Our Ref: PoTLL/TFGP/EX/2
Your ref: EN010092

Application for the Thurrock Flexible Generation Plant Development Consent Order

Response to Thurrock Power Ltd's Letter of 16 October 2020 [AS-008]

Figure 3.1: Link Locations

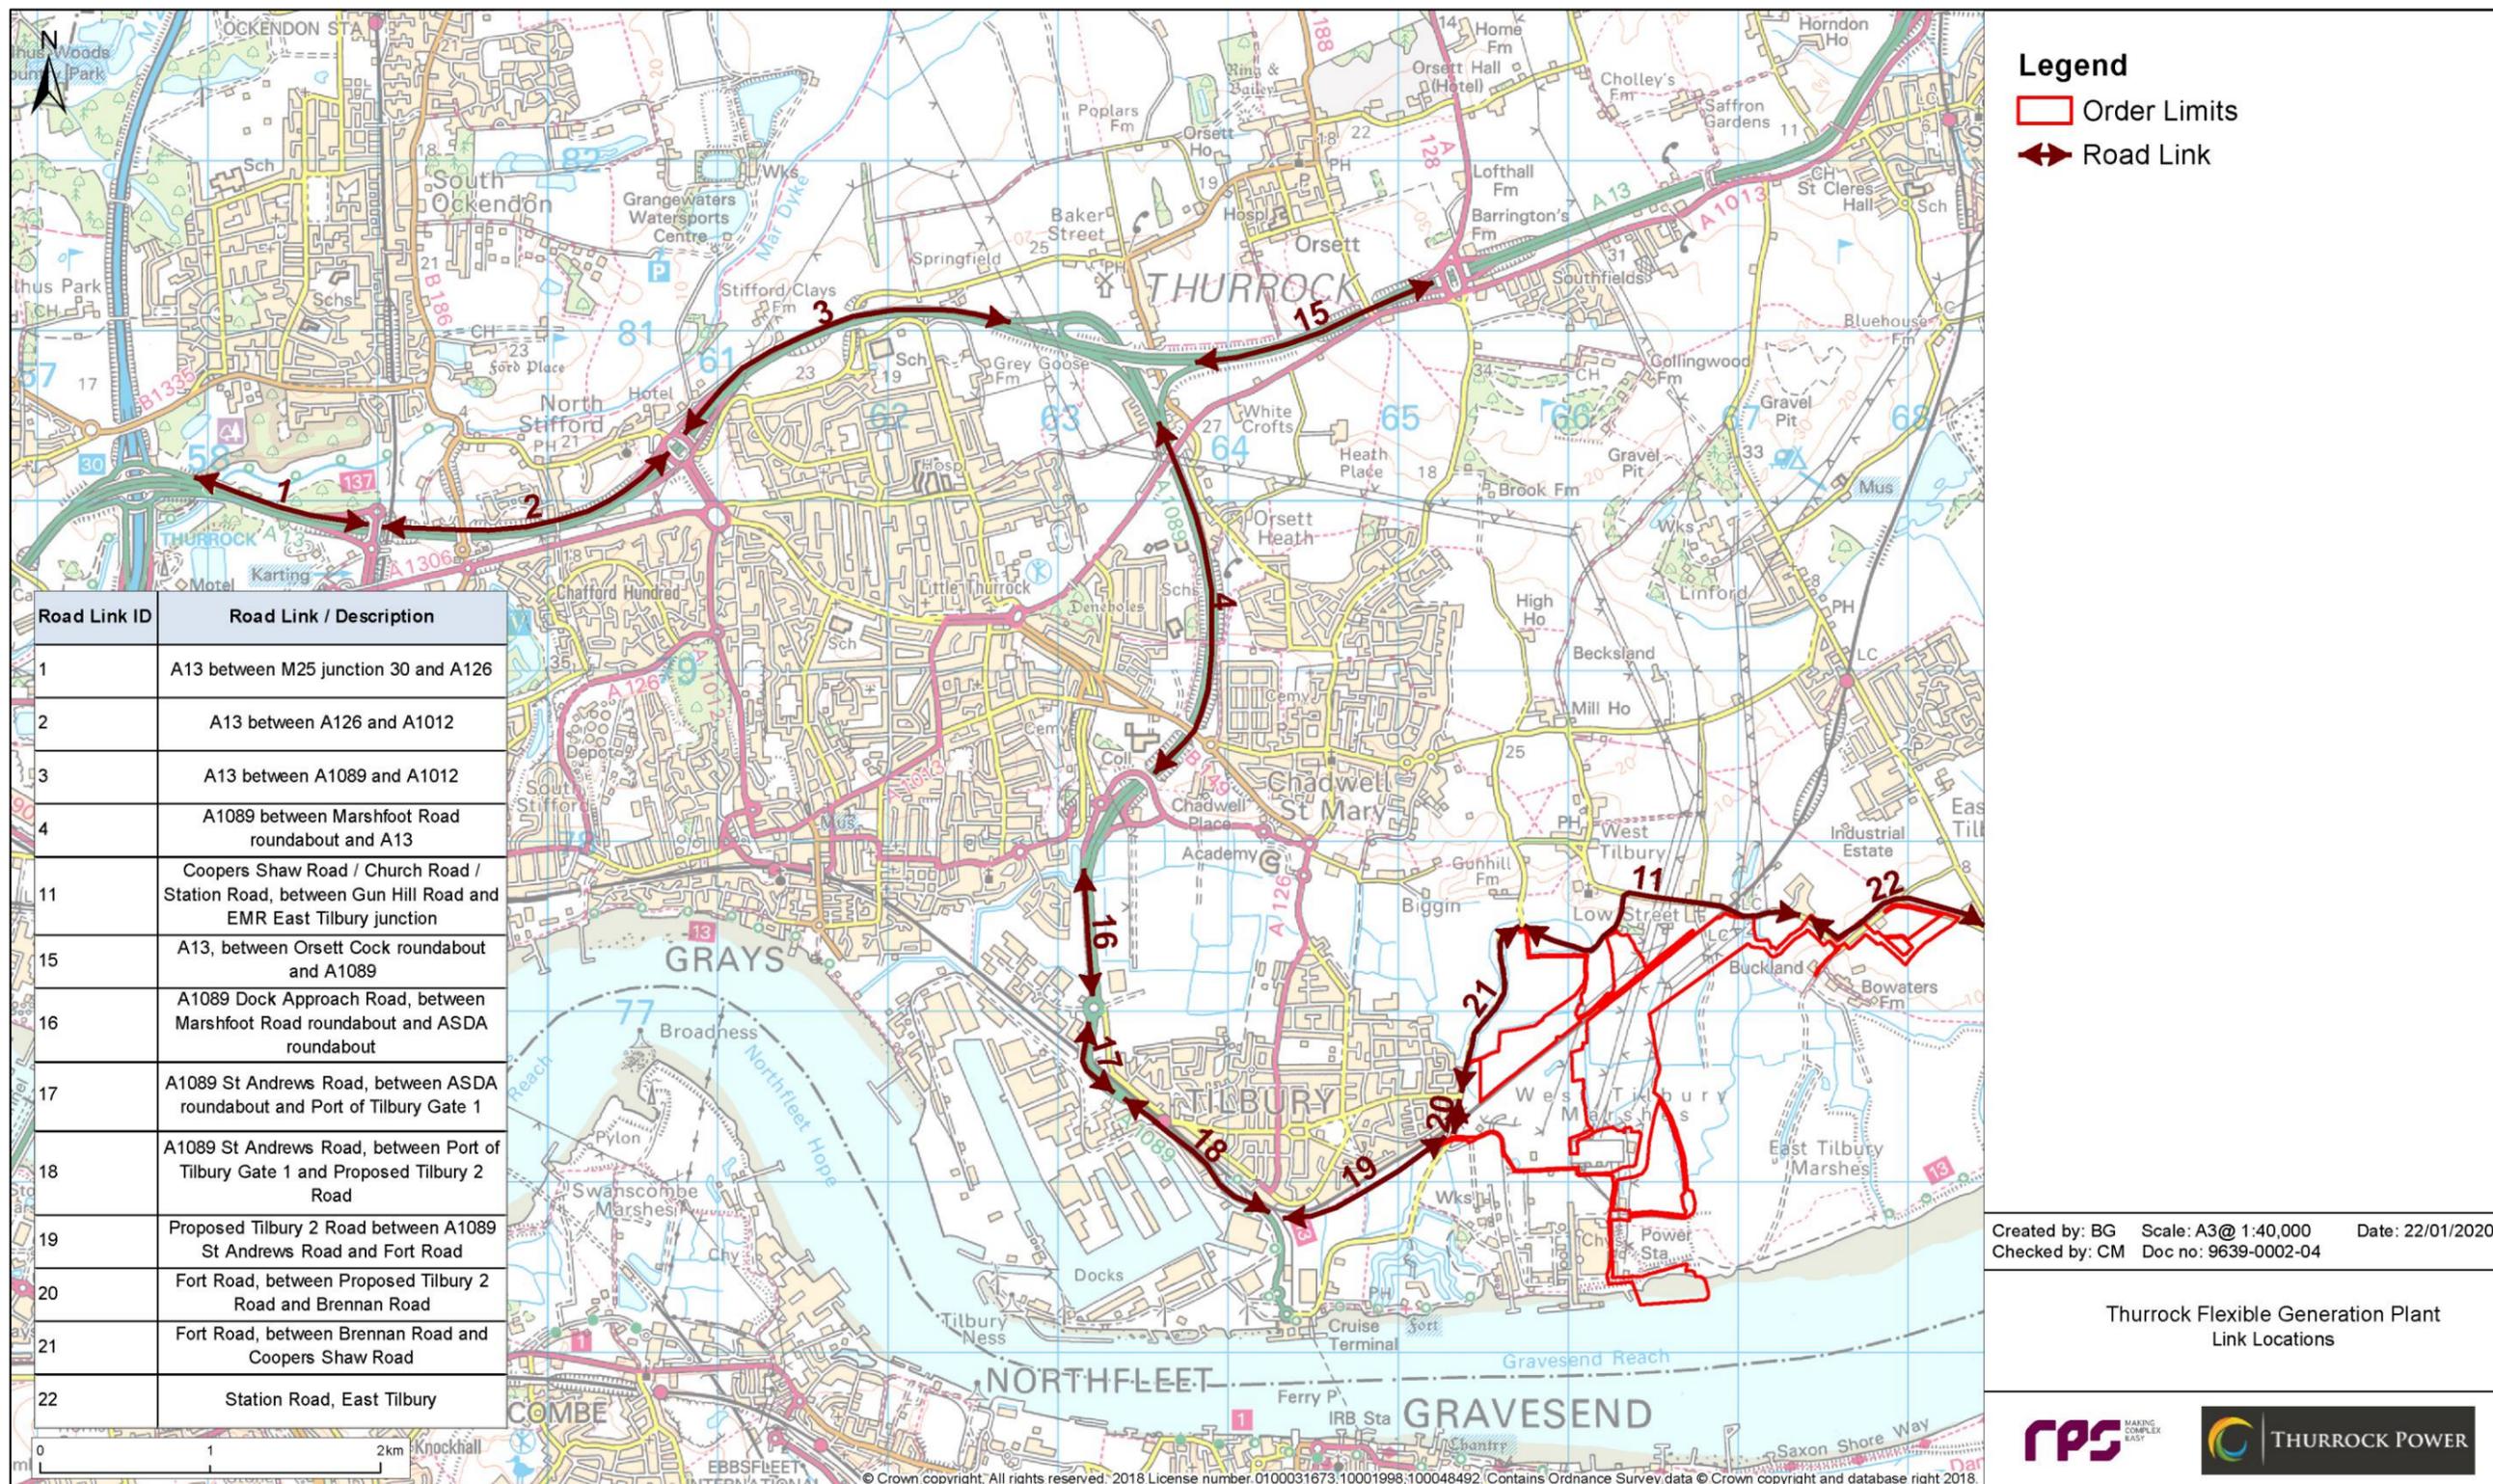
30. On further analysis of the Transport Assessment and the recent cumulative update, PoTLL also has a further concern that the current material does not appear to consider the impacts of the Project on the performance of the junctions at either end of the 'link 19' road in the Transport Assessment, referred to as 'Proposed Tilbury2 road between A1089 St Andrews Road and Fort Road'.

33. Failure to consider the impacts on this junction is another example of the failure of the Applicant to properly consider the impacts on the Port as a whole. An understanding of the impacts on this junction is therefore also required in order to enable the wider impacts of the Project on Port operations to be understood and assessed. Absent this information, a key part of those impacts will not be able to be known, or properly informed representations to be made in response.
